DECISION DELEGATED TO HEAD OF PLANNING

Application No: H17-0028-26 **Applicant:** Mr J Heppenstall

Proposal: Demolition of existing dwelling and construction of new replacement dwelling and double garage

Location: 20 The Reservoir Surfleet Spalding

Drawing No - 1a

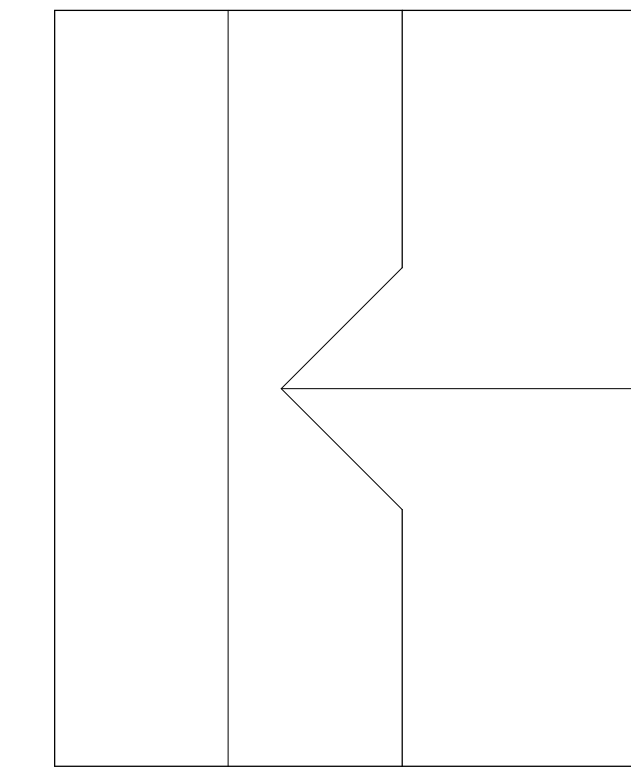
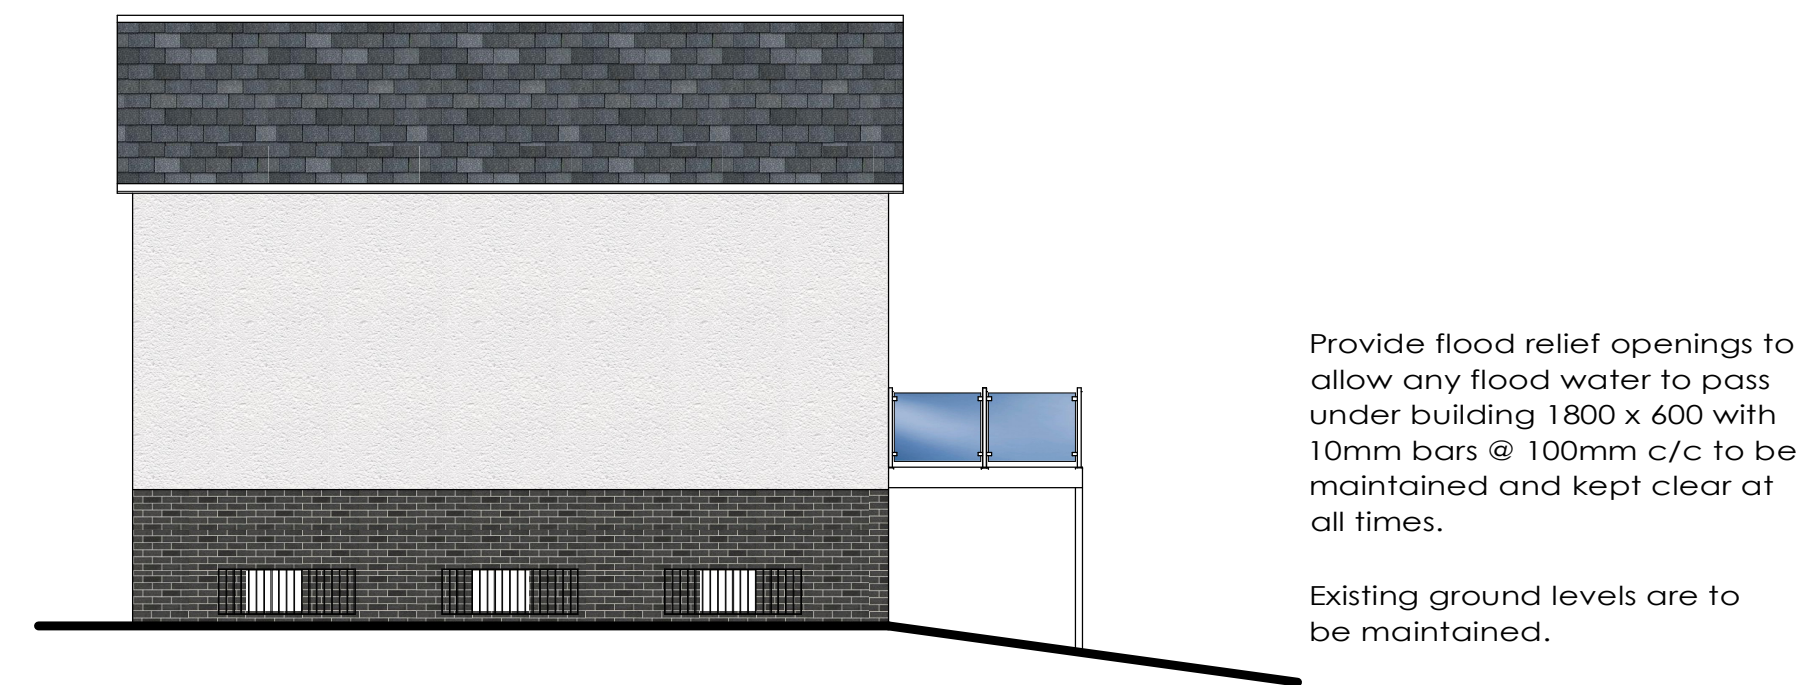
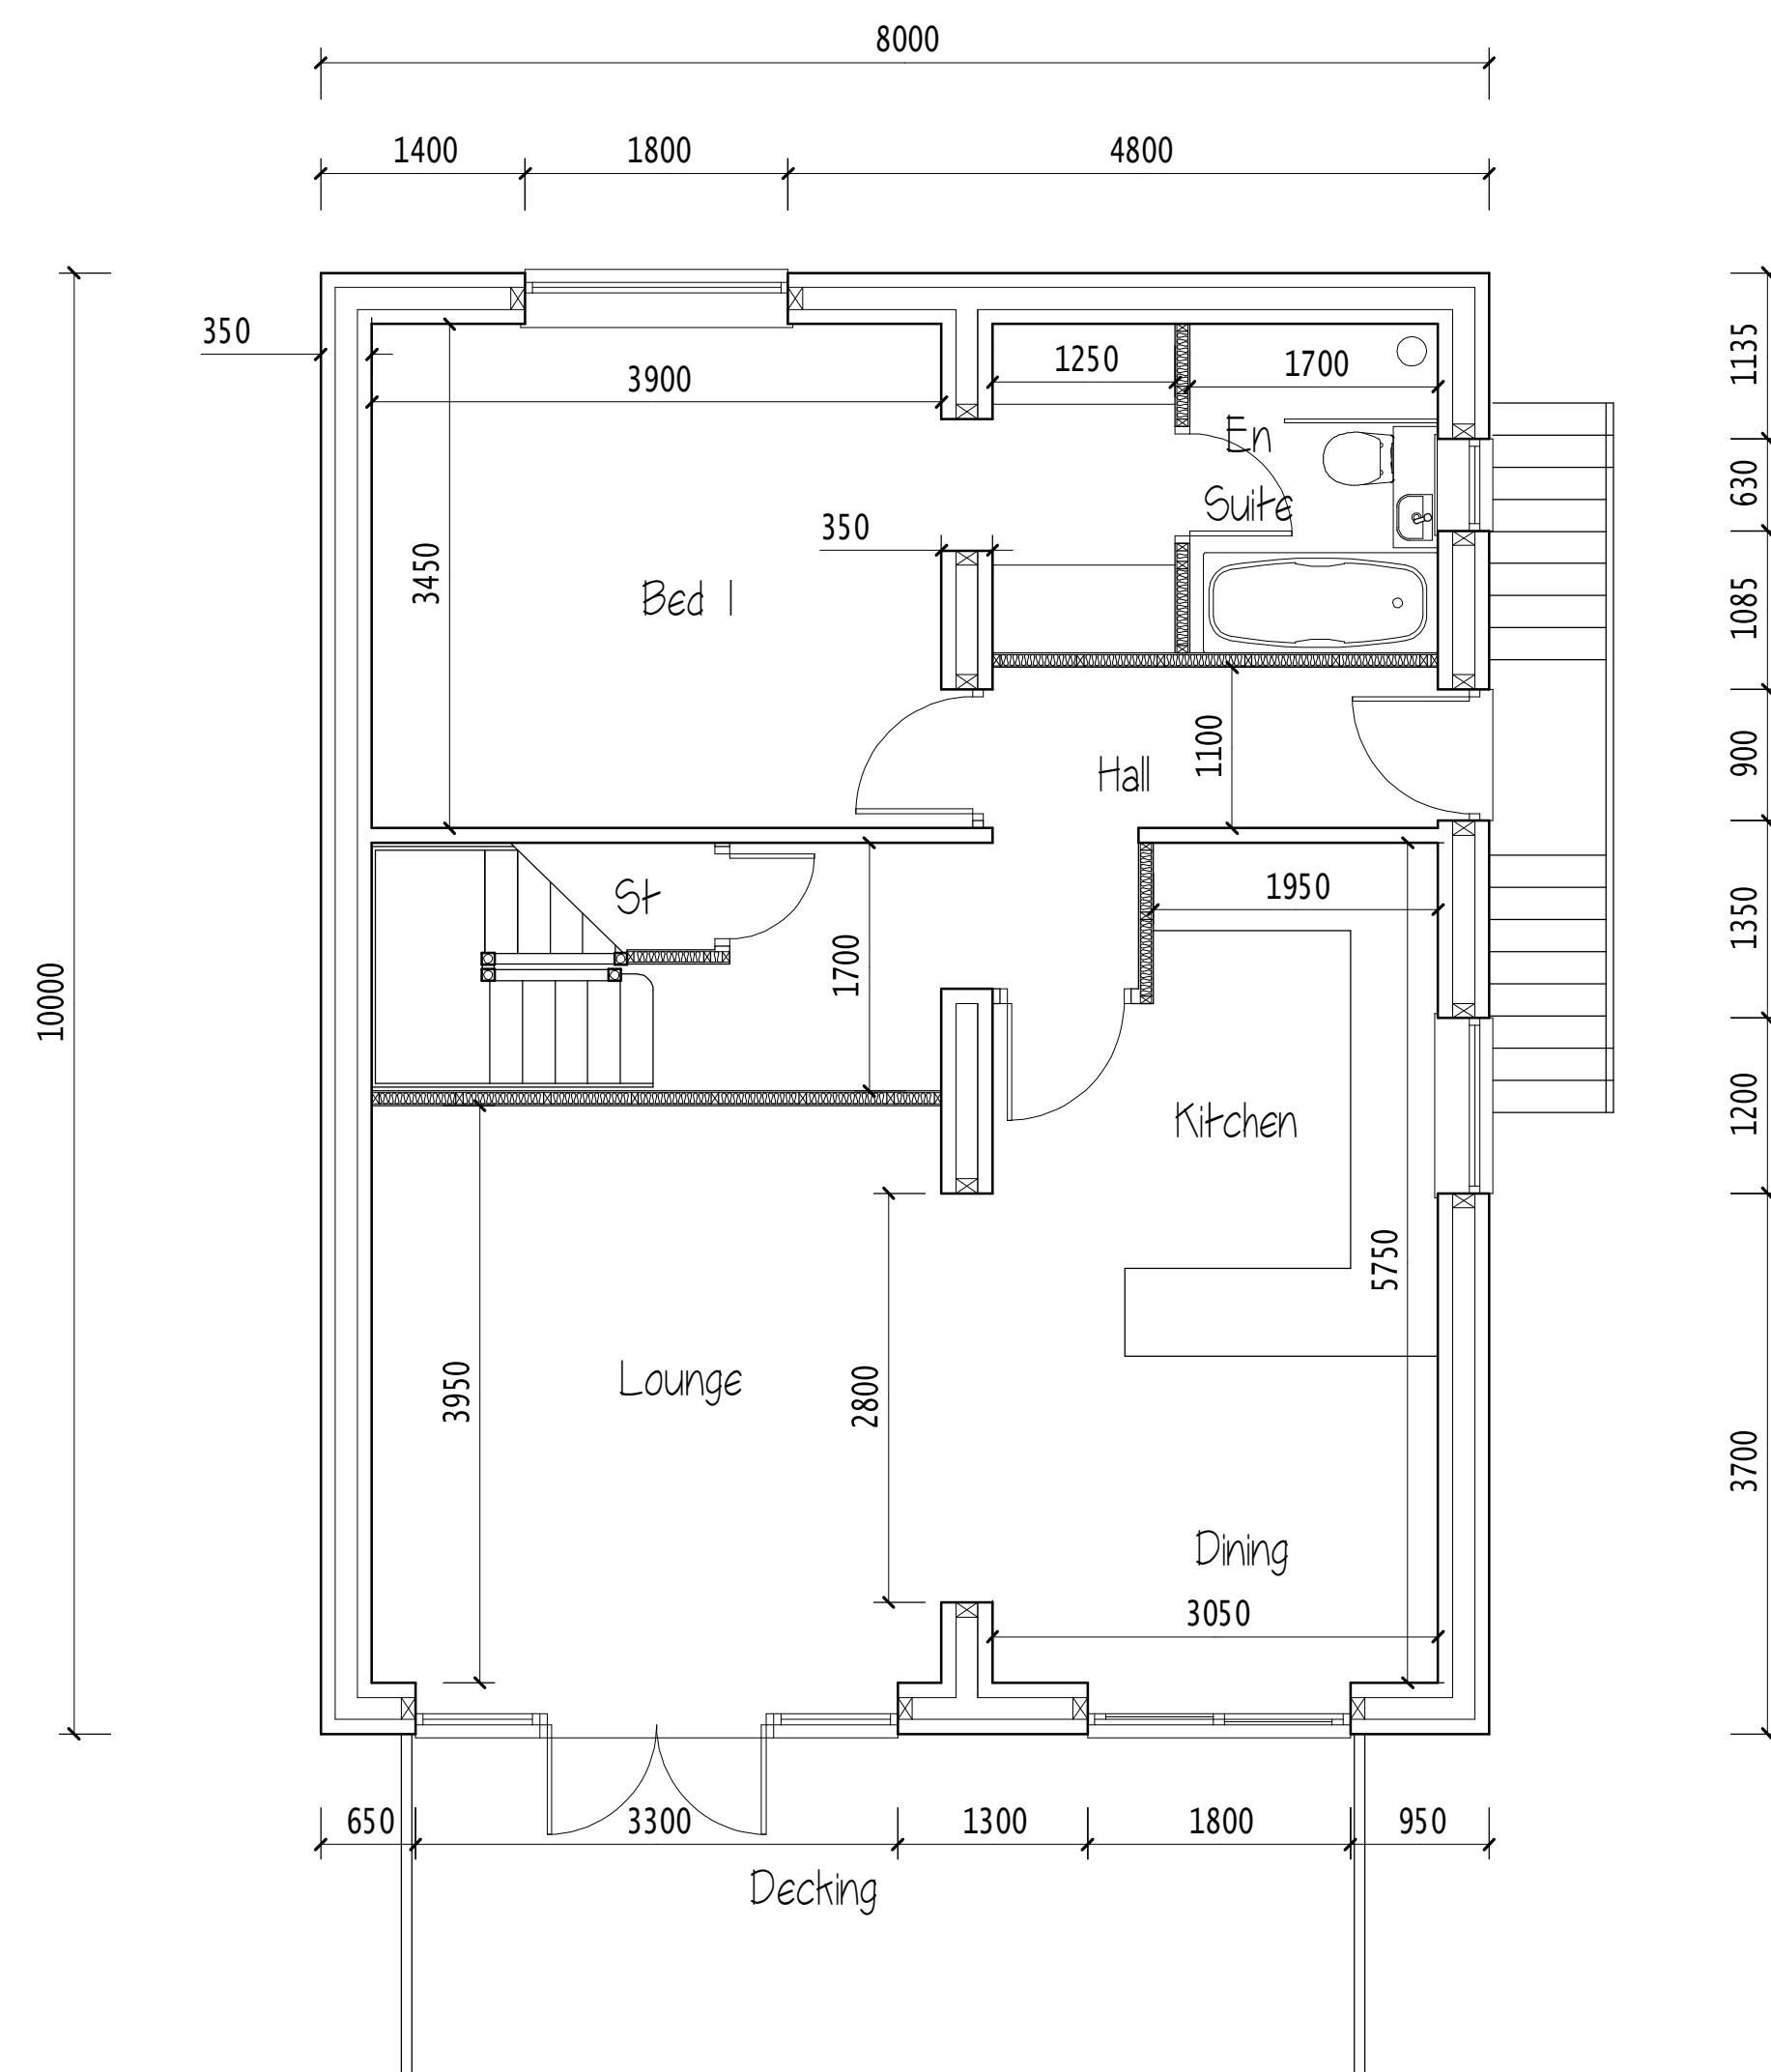
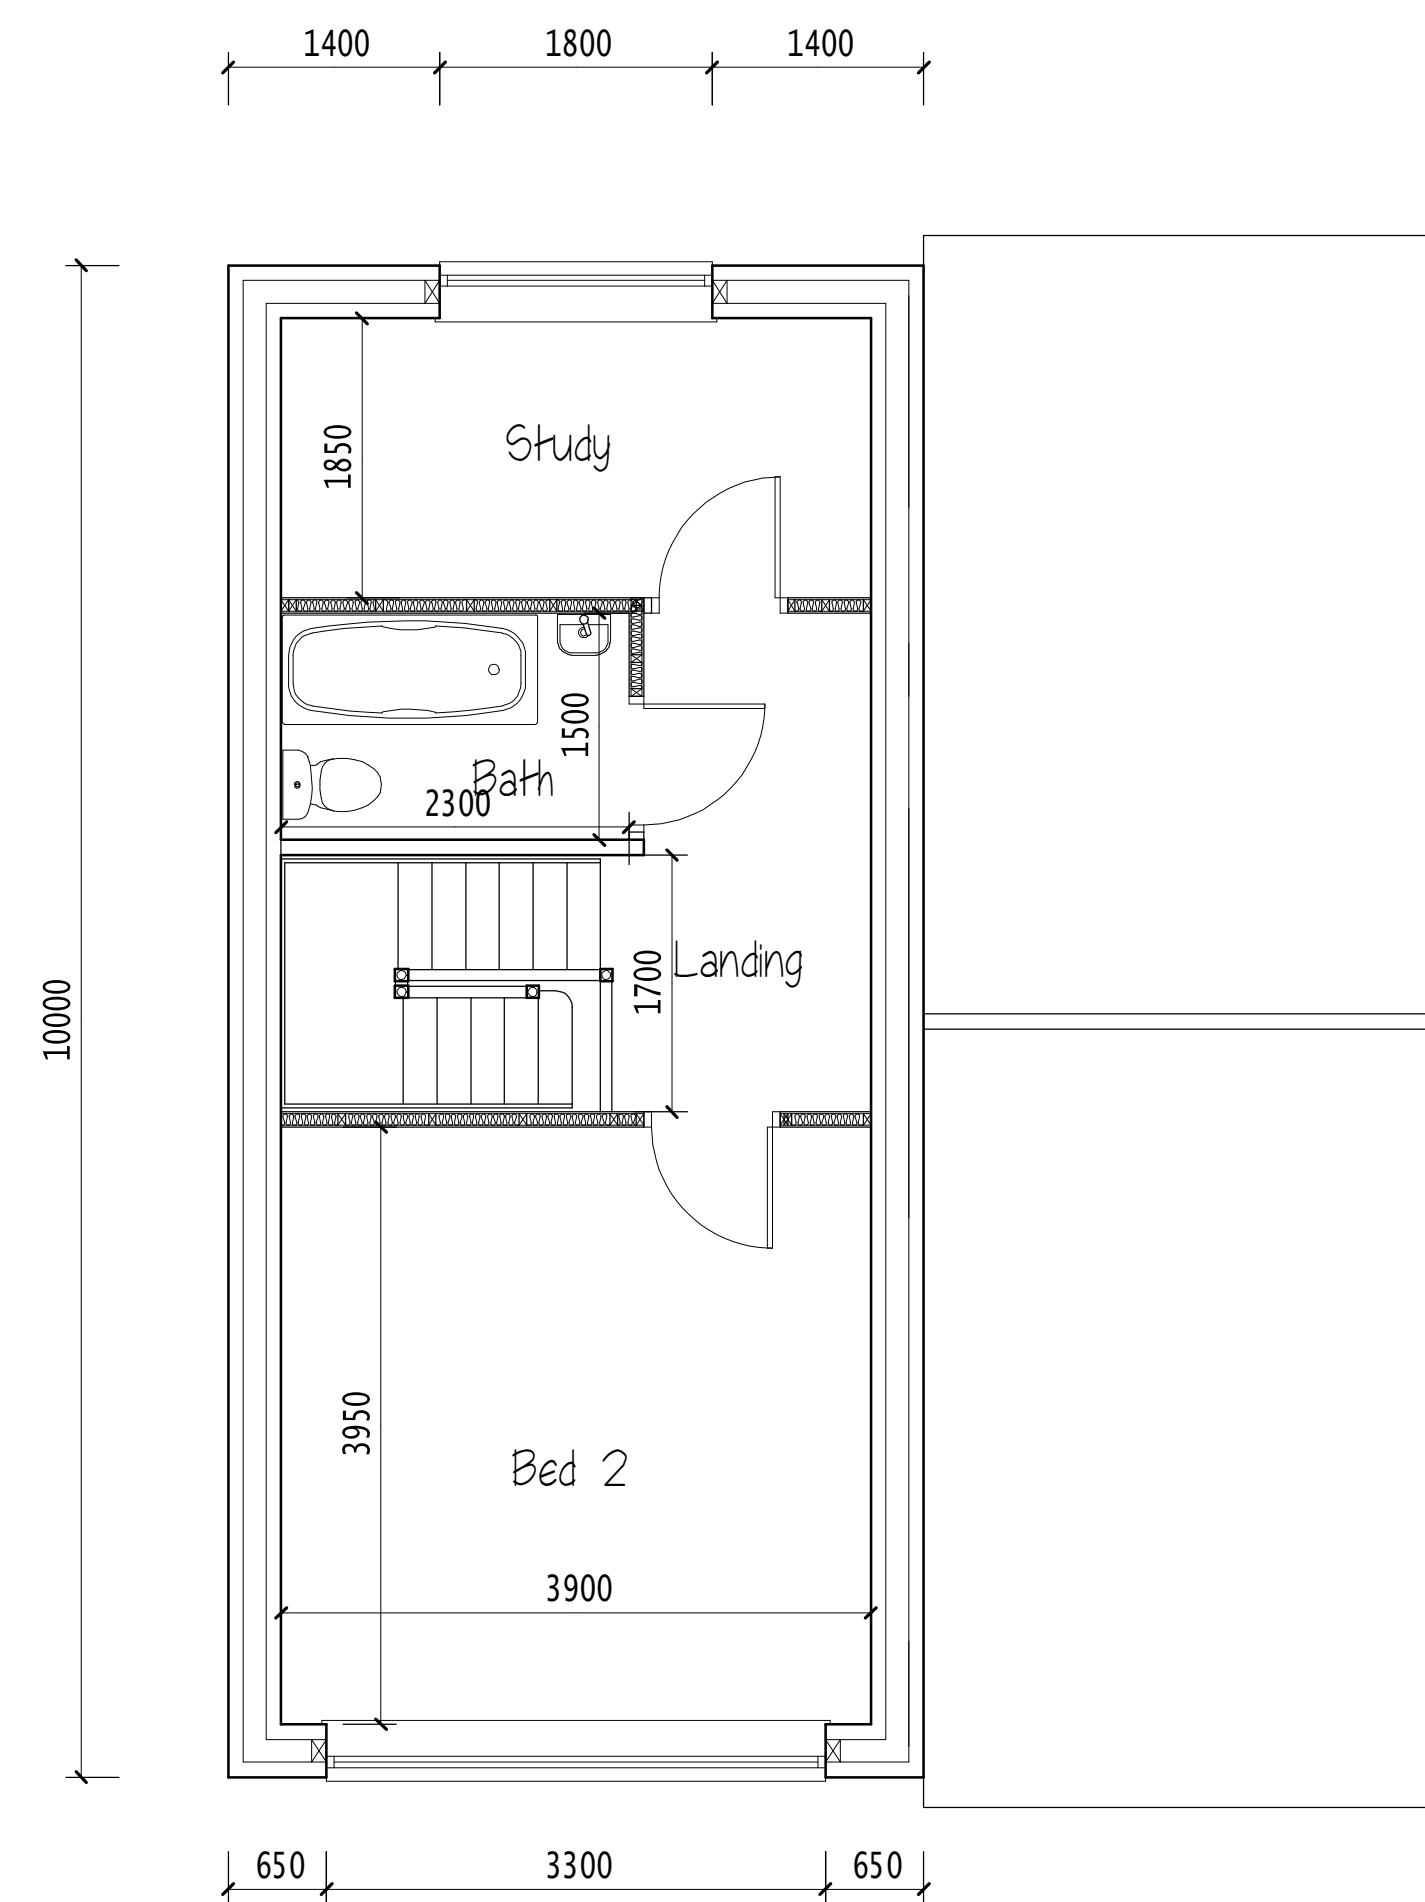
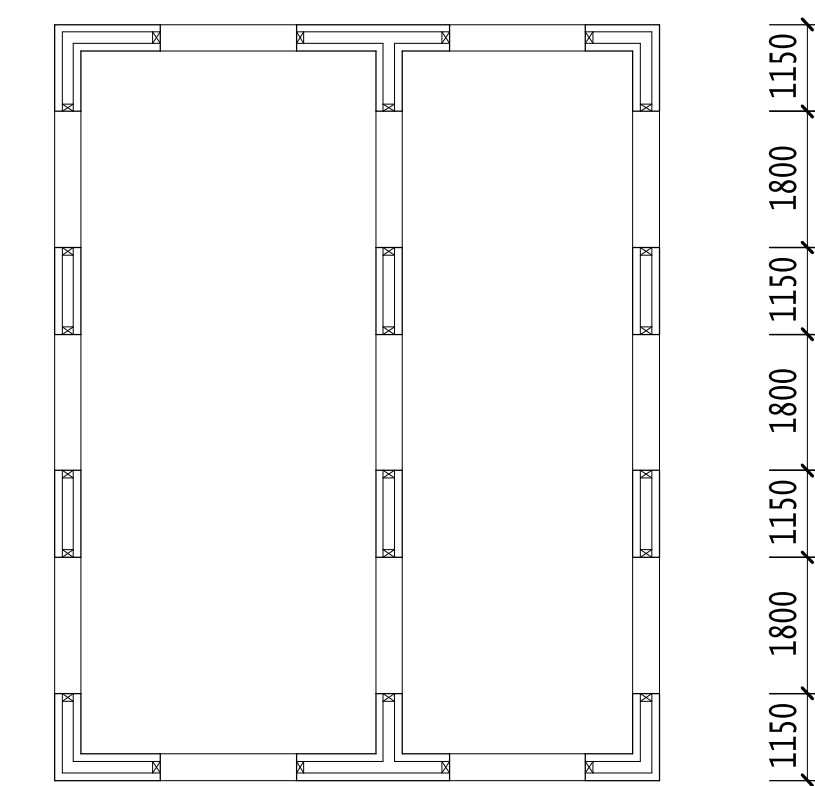
The proposed replacement dwelling would result in a larger dwelling within the site. For example, the proposed replacement dwelling measures 10m in length and 8m in width. The dwelling is proposed to feature two gable end roof forms with gable ends of the southern, northern and eastern elevations. The finished floor levels are proposed to be higher from the ground level than the current dwelling for flood risk mitigation purposes. This has resulted in a higher roof form as the dwelling would measure 8m up to its ridgeline at its tallest point, and 7.4m in height on the side portion of the dwelling.

Initially, concerns were raised with the proposed scale of the dwelling as no street scene plans had been provided to show a comparison with neighbouring dwellings. The initial plans also did not show an accurate portrayal of the height of the dwelling as the plans did not account for the required finished floor levels. A street scene plan was subsequently provided and this has been taken into account.

Whilst the replacement dwelling would be taller than the dwellings on either side of the site, it is recognised that there is a variance in terms of dwelling heights within the street scene, particularly where replacement dwellings have been erected. As set out previously, the dwelling needs to include finished floor levels above the ground and this means that the dwelling is taller than it would be if this was not required for flood risk mitigation purposes.

Two side elevation windows are proposed on the eastern elevation which faces towards 21 The Reservoir. One of the windows would connect to a bathroom and the other window would connect to a kitchen. Although these windows do not appear to face directly towards neighbouring habitable windows, it would be considered appropriate to require obscure glazing for these windows in the interests of maintaining privacy given their proximity to the boundary with No. 21.

Therefore, on balance, it is considered that the design of the dwelling is acceptable and the proposals accord with part 4.
